From: Jules Chatterton | Brennan and Chatterton [REDACTED]
Sent: 25 August 2021 15:41
To: Kathryn Welch
Subject: RE: EP/94/21/NMA St Johns Cottage
Attachments: St Johns Cottage Pd Issue 4 -.pdf

From: Kathryn Welch [REDACTED]
Sent: 24 August 2021 15:27
To: Jules Chatterton | Brennan and Chatterton <jules@brennanandchatterton.co.uk>
Subject: EP/94/21/NMA St Johns Cottage

Further to our telephone conversation I've now had an opportunity to consider the plans submitted as part of the above mentioned application.

South Elevation (Rear)

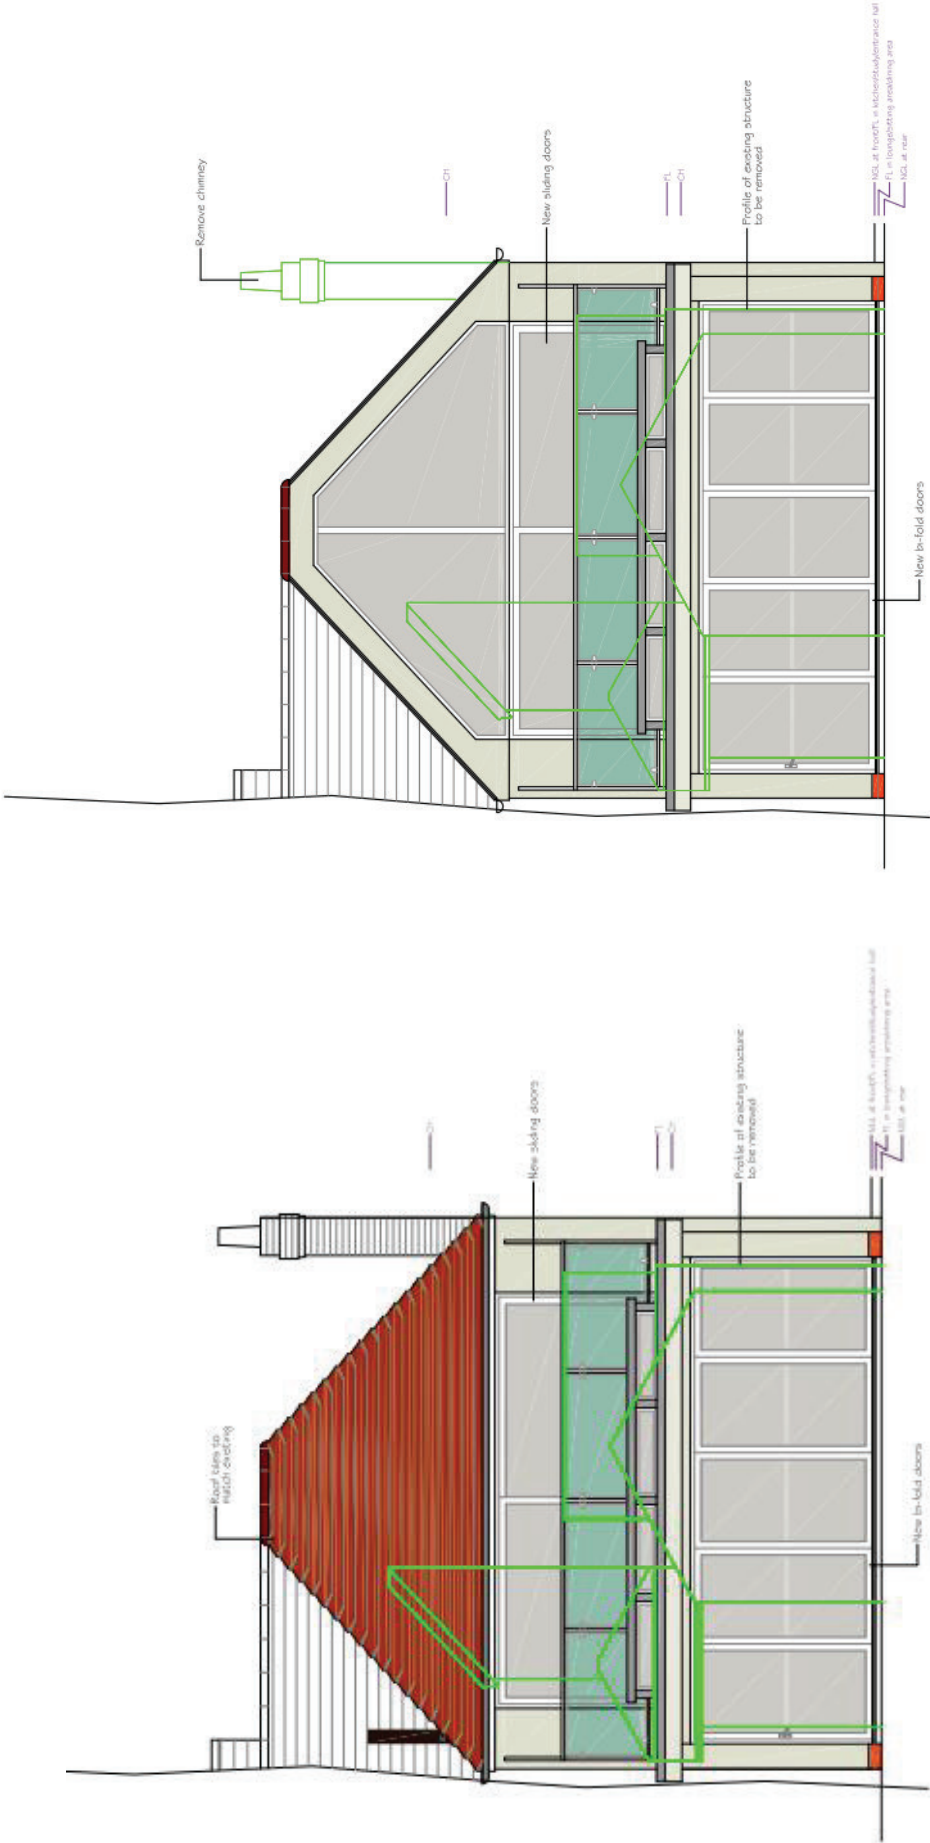
I am of the view that the rear hip to gable alteration along with the glazed gable end would result in '*changes to the external details that would materially alter the appearance of the building*' at the rear of the property. As it stands I would look to refuse the application. I understand that you would be happy to alter the proposed details to suit the NMA requirements and I would gladly accept an alteration to the submitted plans, removing the hip to gable and glazed feature.
